City File Number: DEPN-25-0173 / County File: OAR265

Review 2

OAR2610: Rock Creek Mesa Development Plan

Review 2: EPC DPW Stormwater has the following comments:

DP2.01

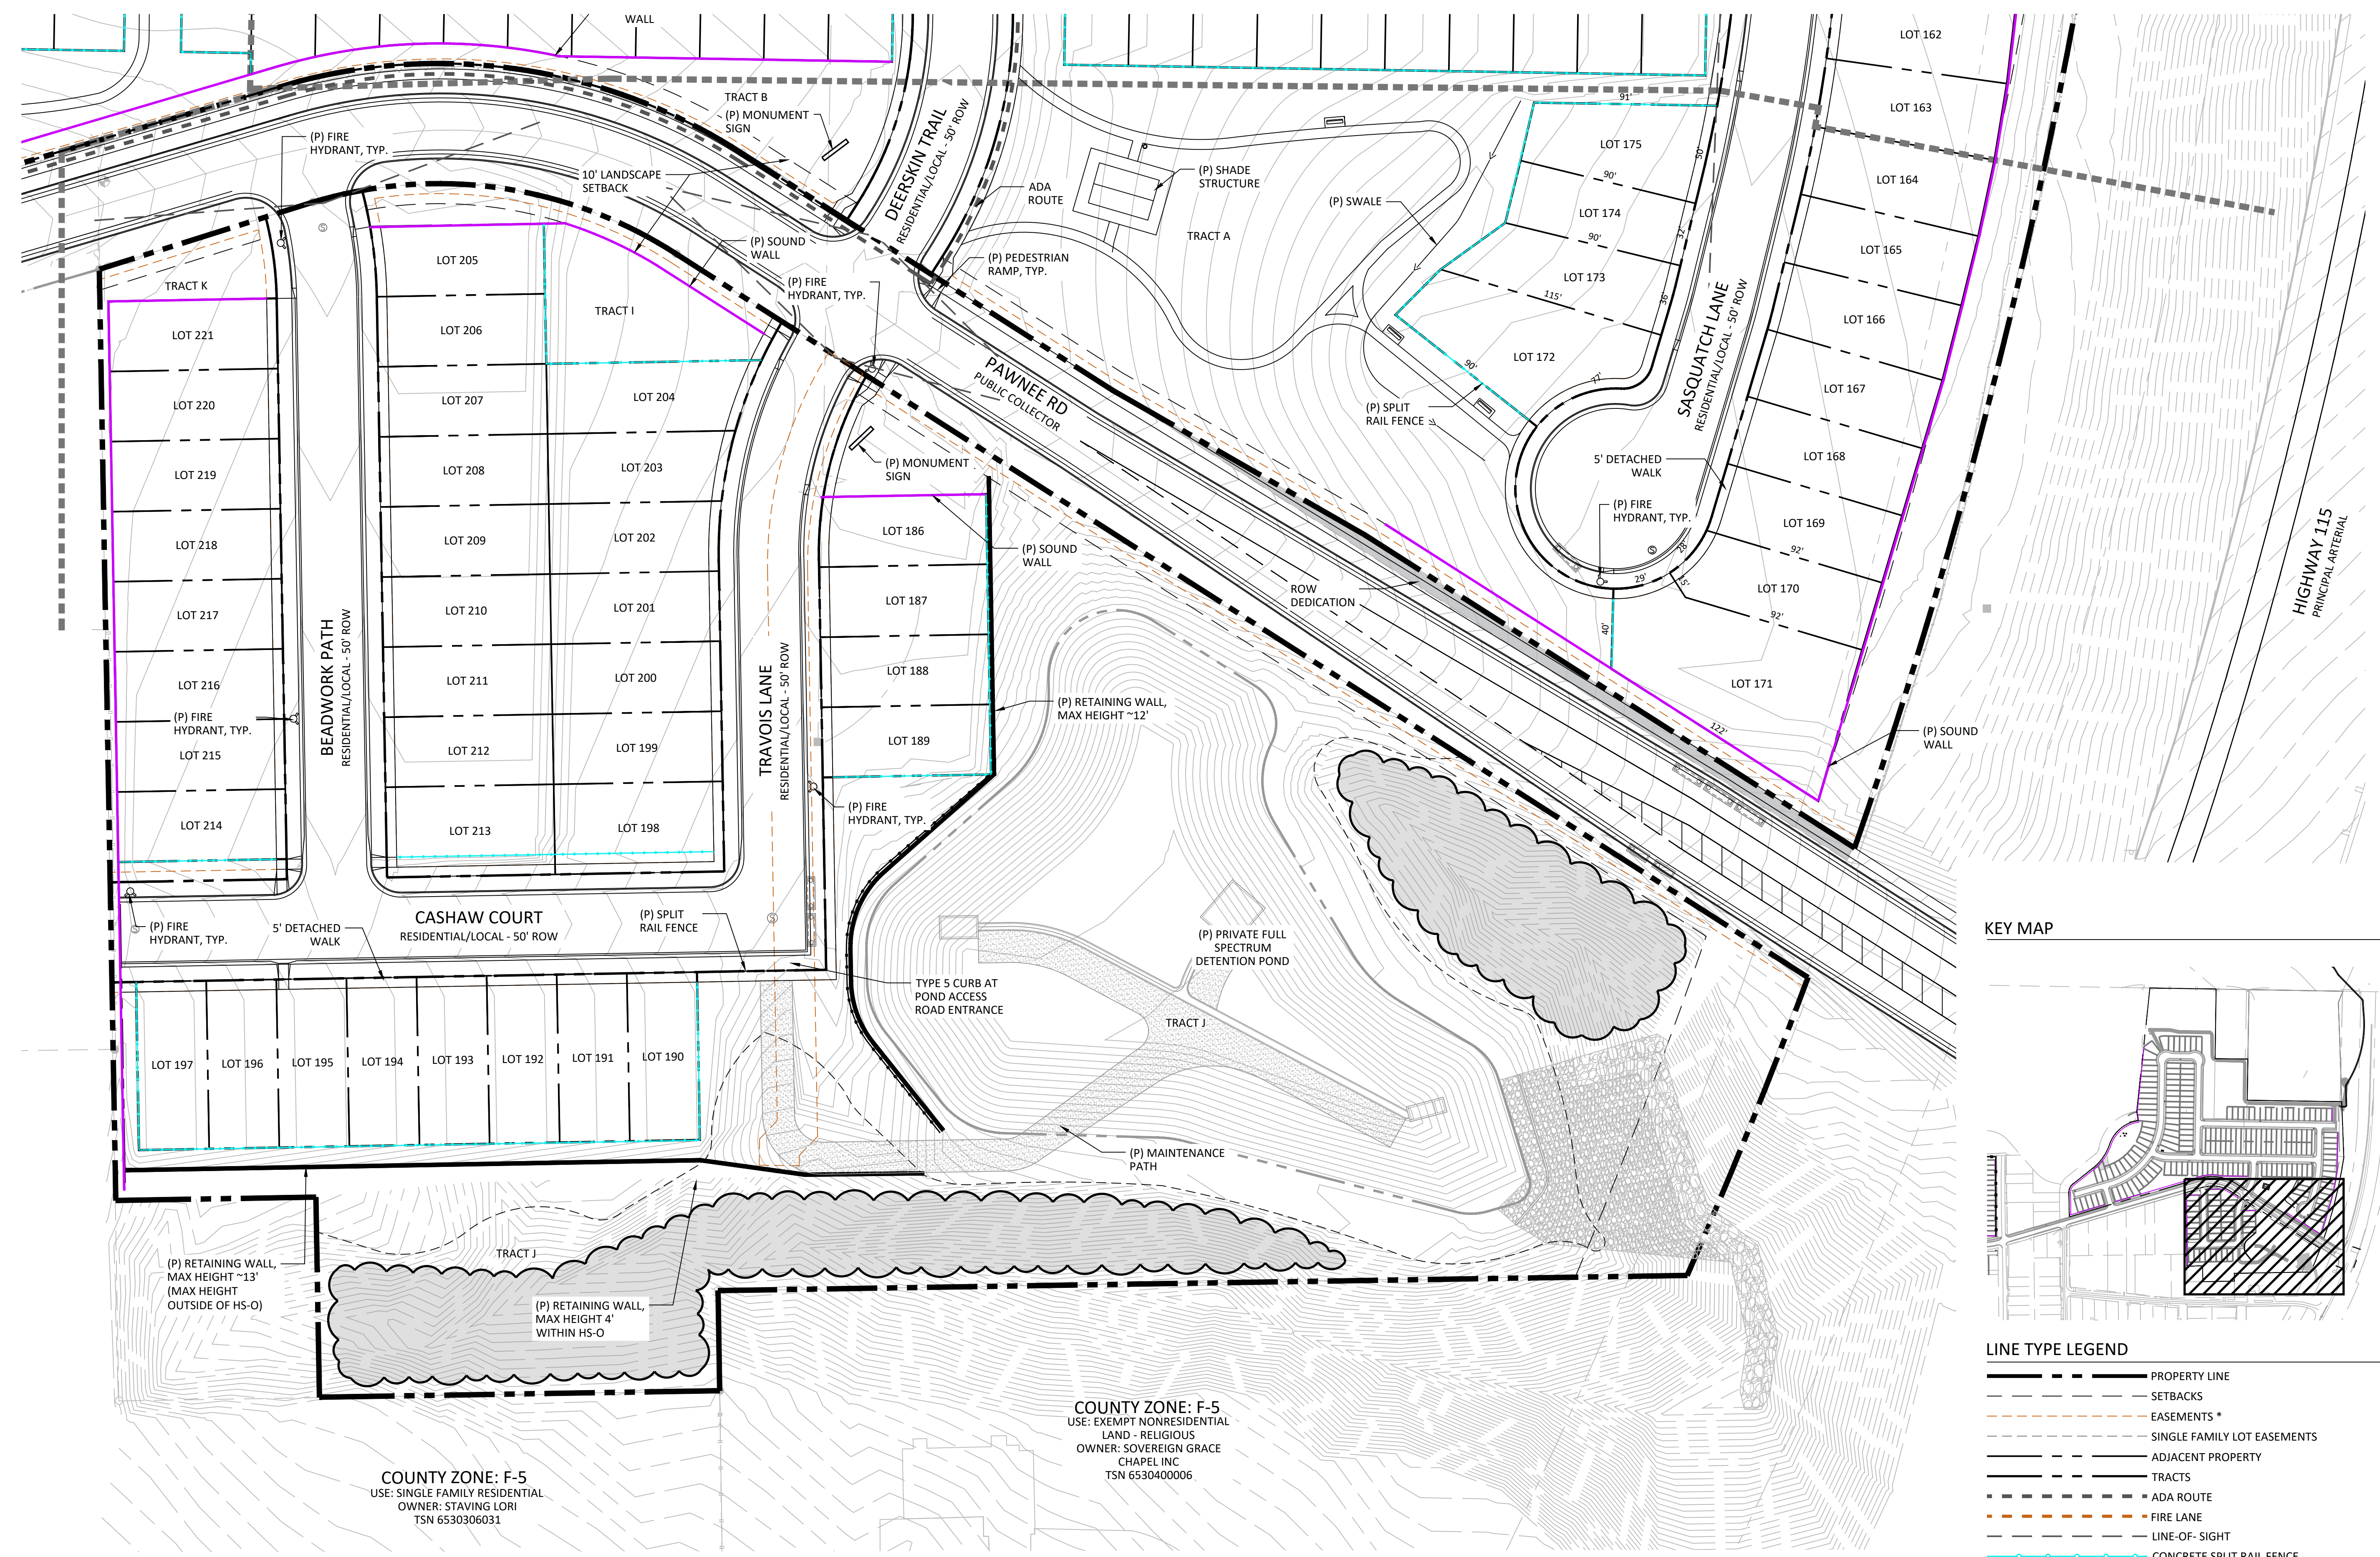
Overall comment: Show the County/City jurisdiction boundary line on the plans. Some of the work on

Pawnee and Piute roads appear to be in ROW. Verify.
